Recommendation Report for Planning Permission for Works or Extension to a Dwelling

REF NO: CM/12/21/HH

LOCATION: Southdown Cottage
Horsemere Green Lane
Climping
BN17 5QZ

PROPOSAL: Two storey side extension.

Drawing No.
1479/P02

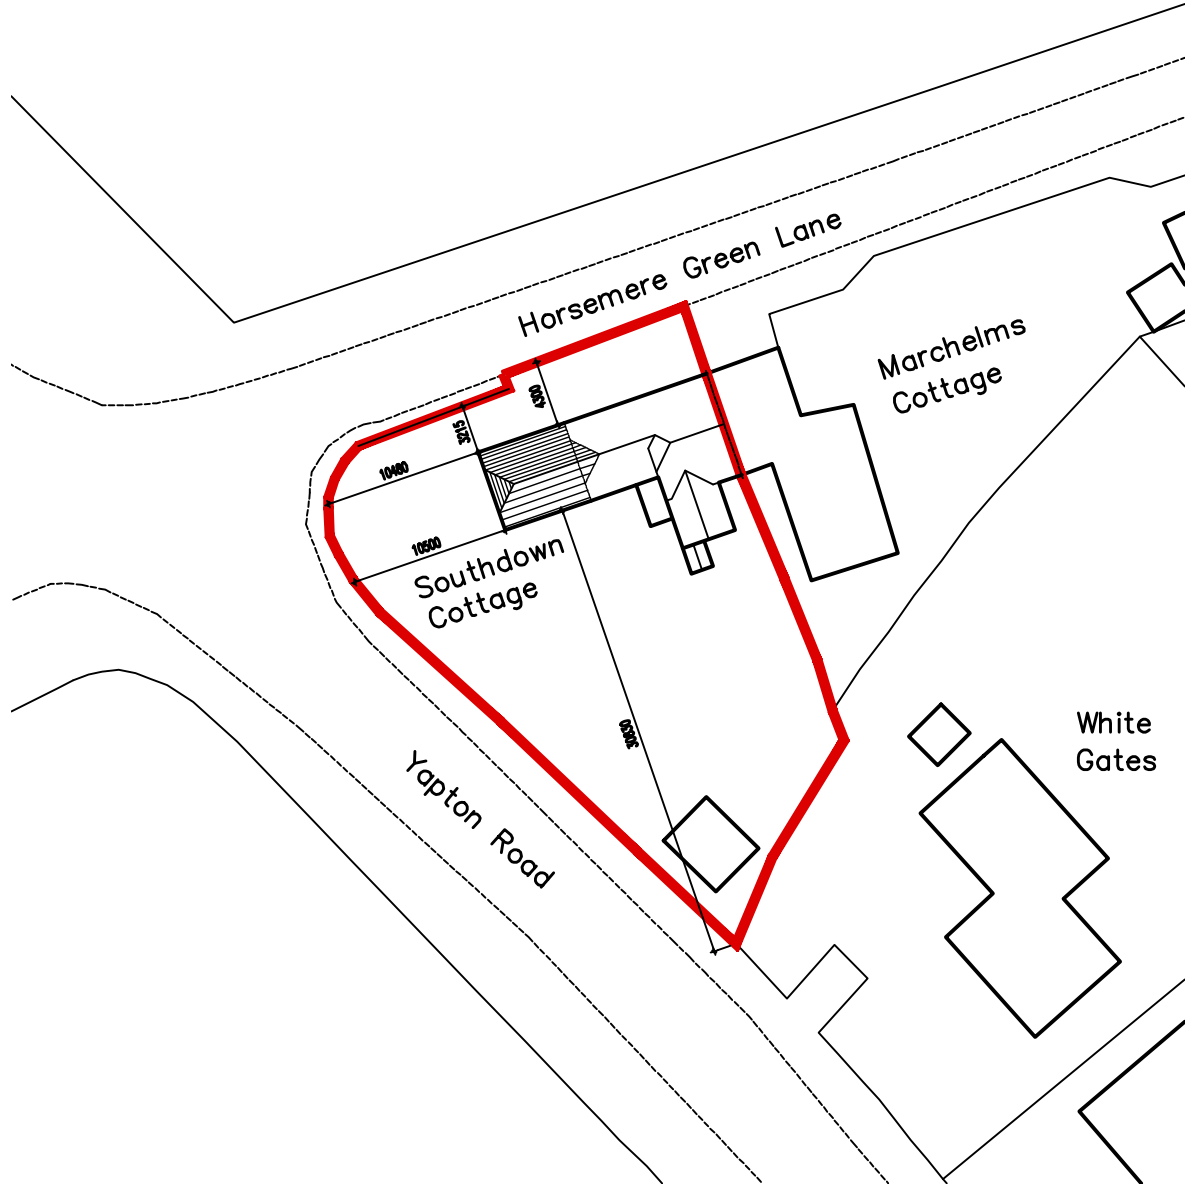
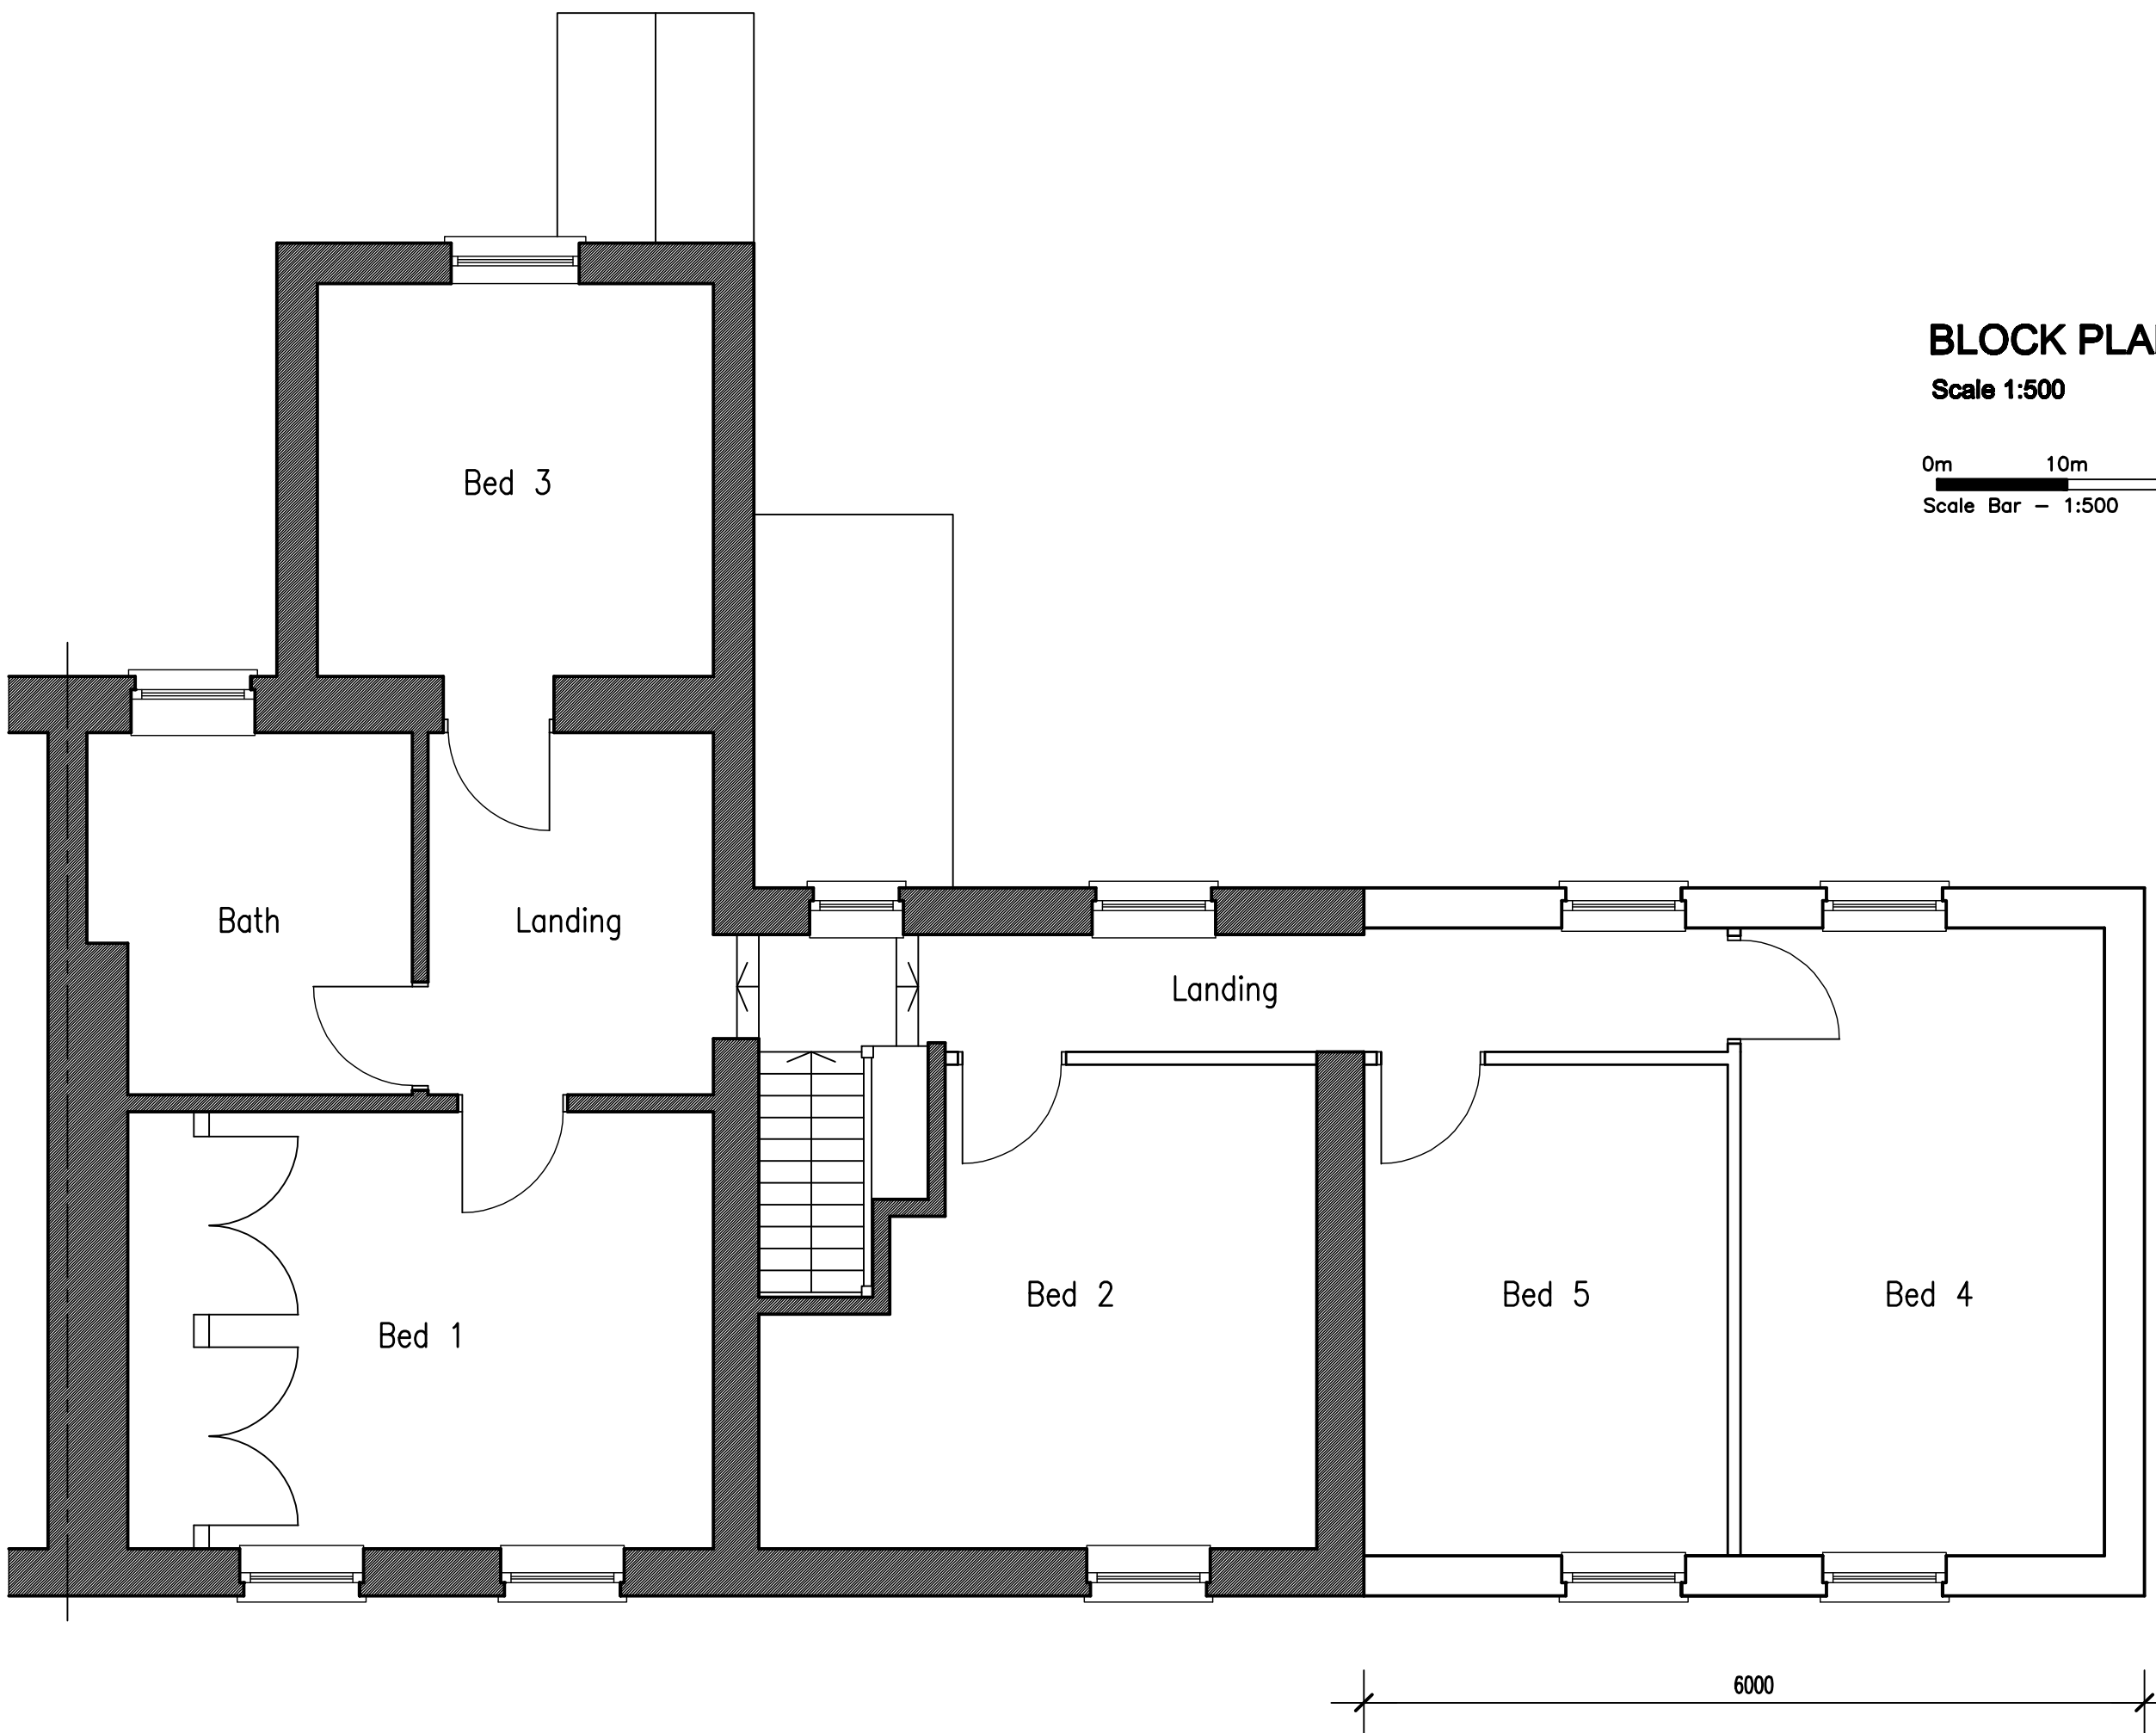
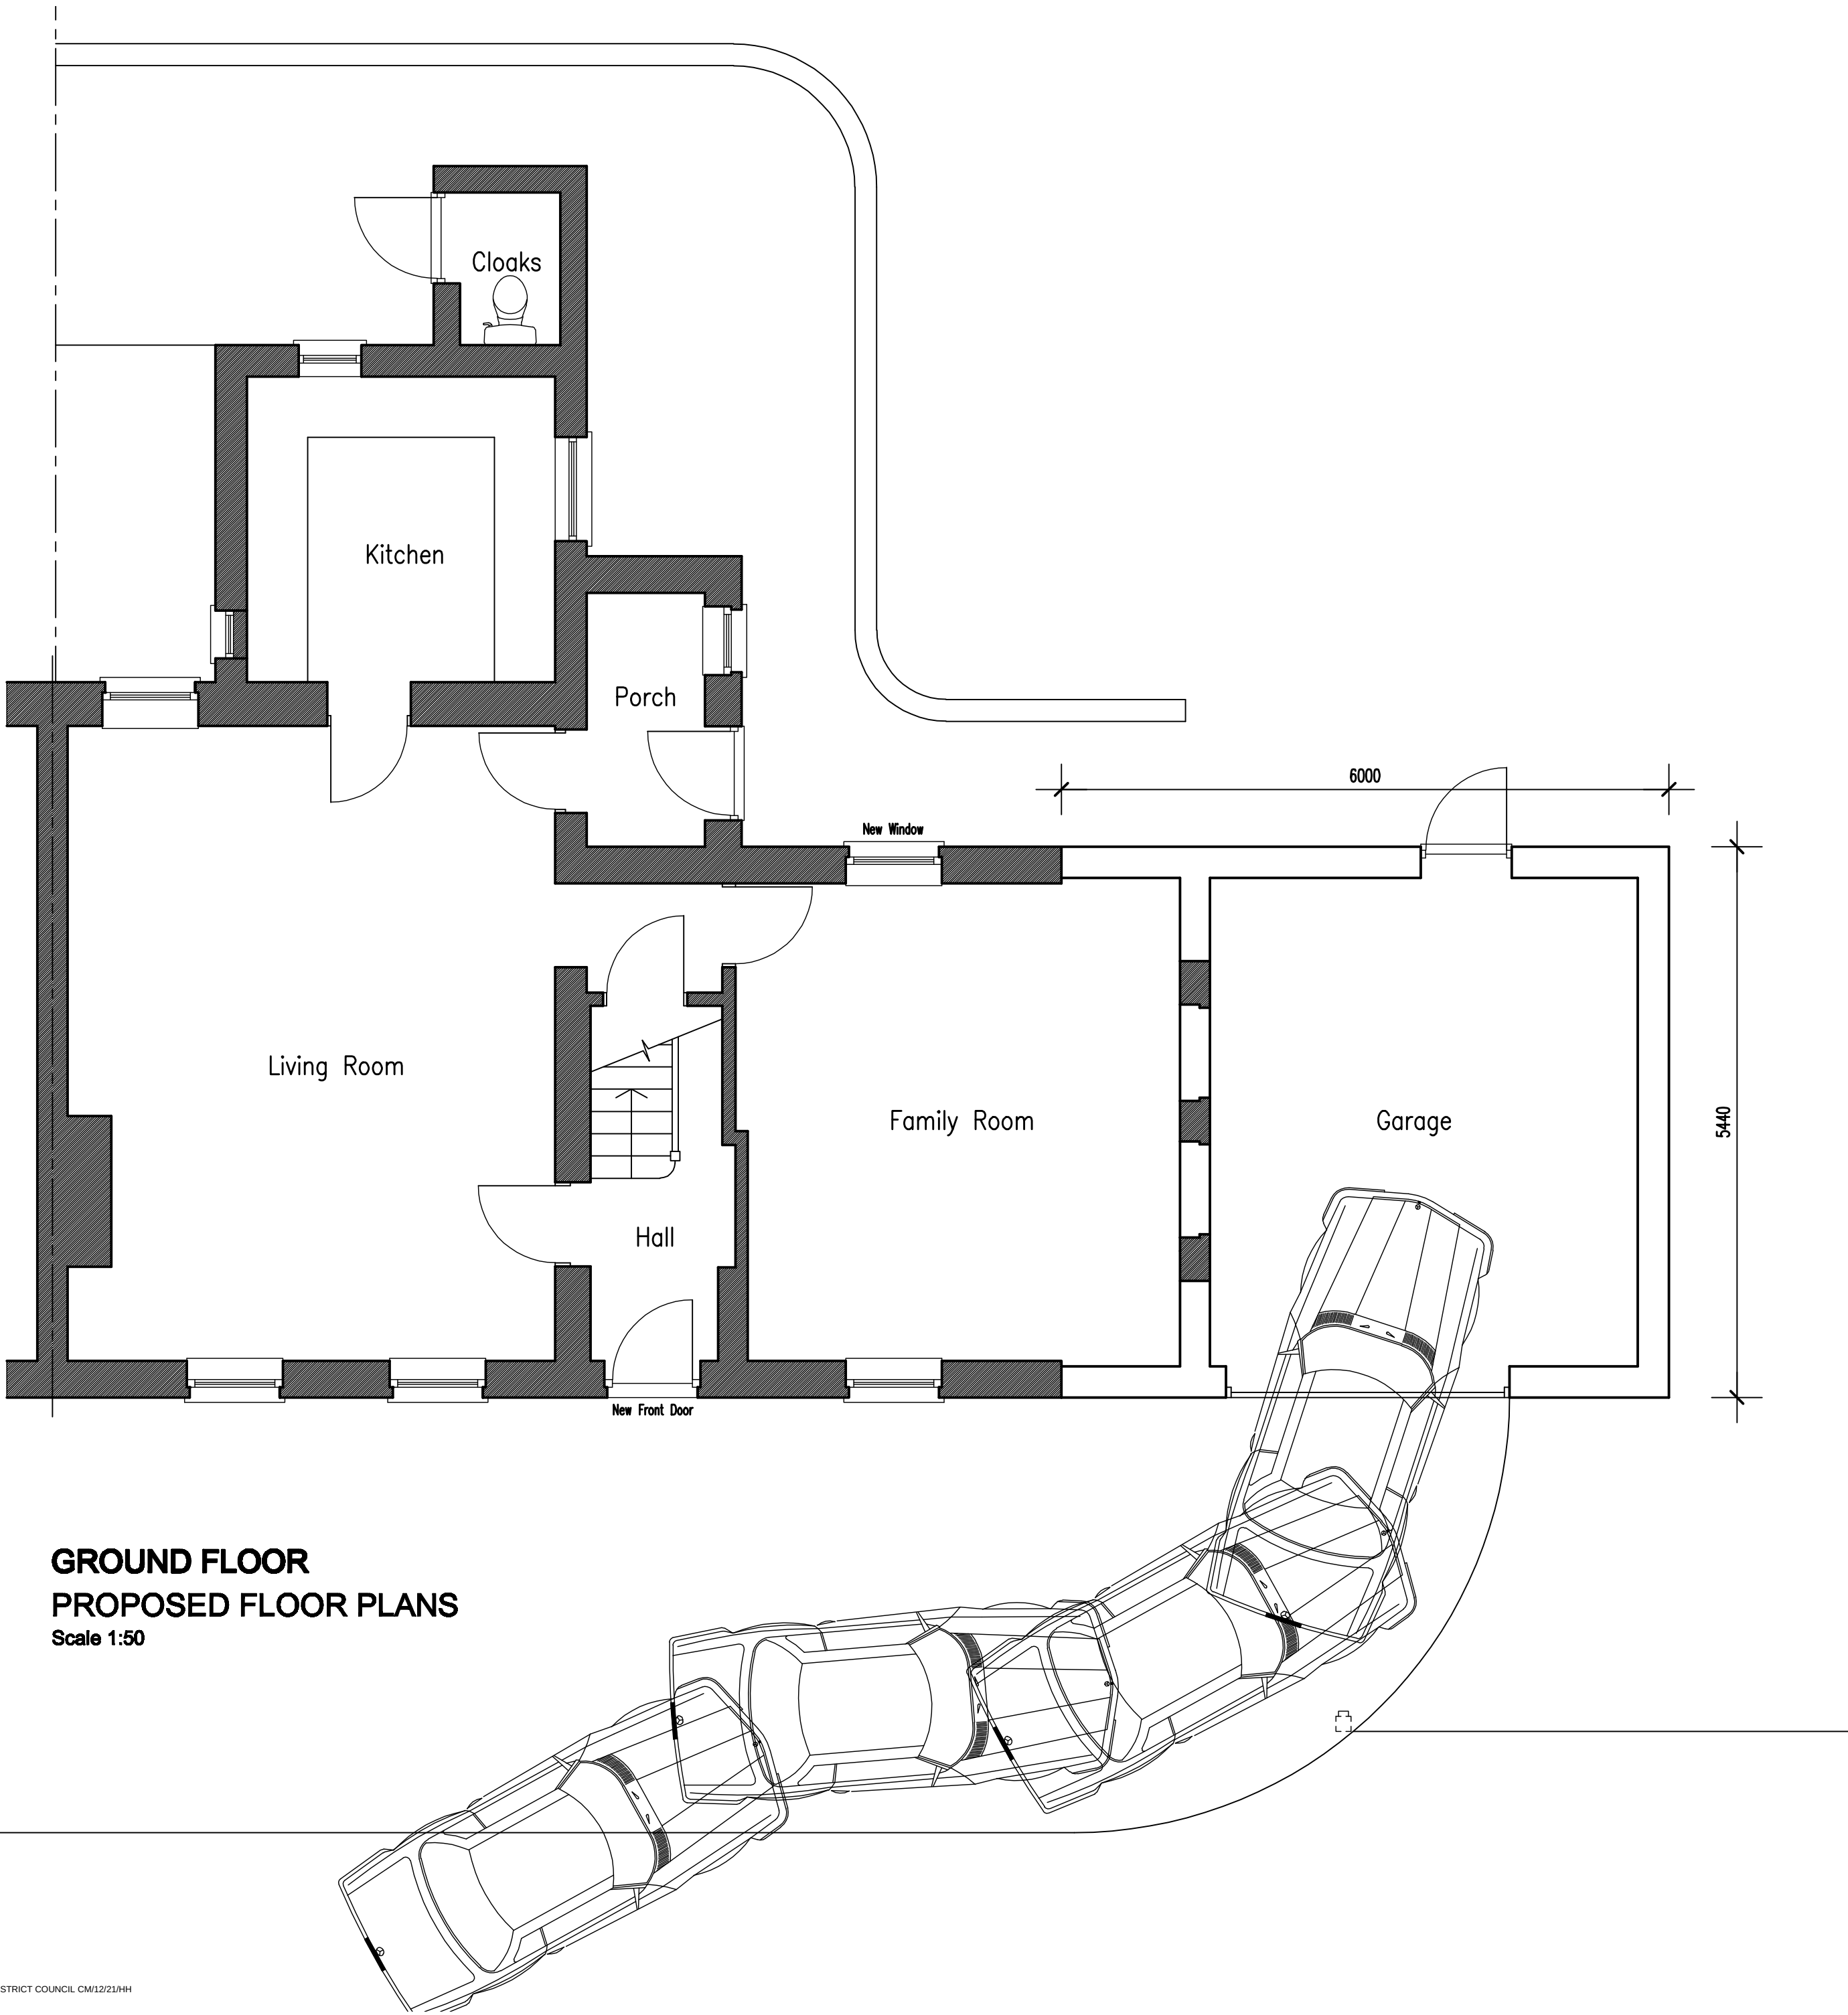
DESCRIPTION OF APPLICATION The proposal is for a 2 storey side extension measuring 6m by 5.4m in area with a ridge height of 8.25m, eaves height of 5.5m which match the height of the existing roof. The materials would match the existing dwelling.

The dwelling is on a corner plot and set back from both site frontages. The 2 storey extension is on the West side of the dwelling in line with the smaller section of the side elevation of the dwelling, and as such, there will be views of the proposal from the public realm resulting in a change in appearance of the dwelling and the area. The extension is approximately adding another third to the width of the building to create a garage at ground floor and 2 bedrooms above and would fill some of the space to the side of the dwelling. The extension would replicate the profile of the roof, eaves and ridge height and would be set in from the rear elevation of the original main house. It would be of an appropriate design and scale for its siting and the materials which are detailed on the elevation plans would match the existing, assisting in visual assimilation of the extension into the existing dwelling. It is considered to appear subservient to the host dwelling due to the matching design and materials. Furthermore, it is set back approximately 4m from the road frontage with Horsemere Green Lane and 10m from Yapton Road and retains adequate space around the dwelling.

It also accords with Part M of the Design Guide in that the form does not overpower the existing or neighbouring properties, integrates the roof form with the existing dwelling, is constructed at the same angle of pitch. and uses materials which match the existing building, responds to existing elevations through the size and positioning of doors and windows and maintains established building lines.

The development is not considered to result in any harmful overbearing or overshadowing impact upon the occupiers of nearby dwellings. This is due to the siting of the development as being away from nearby occupiers. It does not abut the adjacent dwelling Marchelms Cottage to the east. With regard to potential for loss of privacy, the development is not considered to provide any additional views from the application site that are any different to those existing from the application as current. The first floor rear facing windows would be located 30m from the boundary with White Gates and would face onto the front garden area where privacy is not expected.

The property is a locally listed building and subject to consideration against policy HER DM2 of Arun Local Plan. This requires proposals for extensions of such buildings to relate sensitively to the building and respect its architectural/historic interest and to conserve the features which are of interest. The proposal extends the dwelling in a sympathetic, sensitive manner which replicates the features and design of the front elevation and utilises matching materials. The proposal is compliant with this policy.
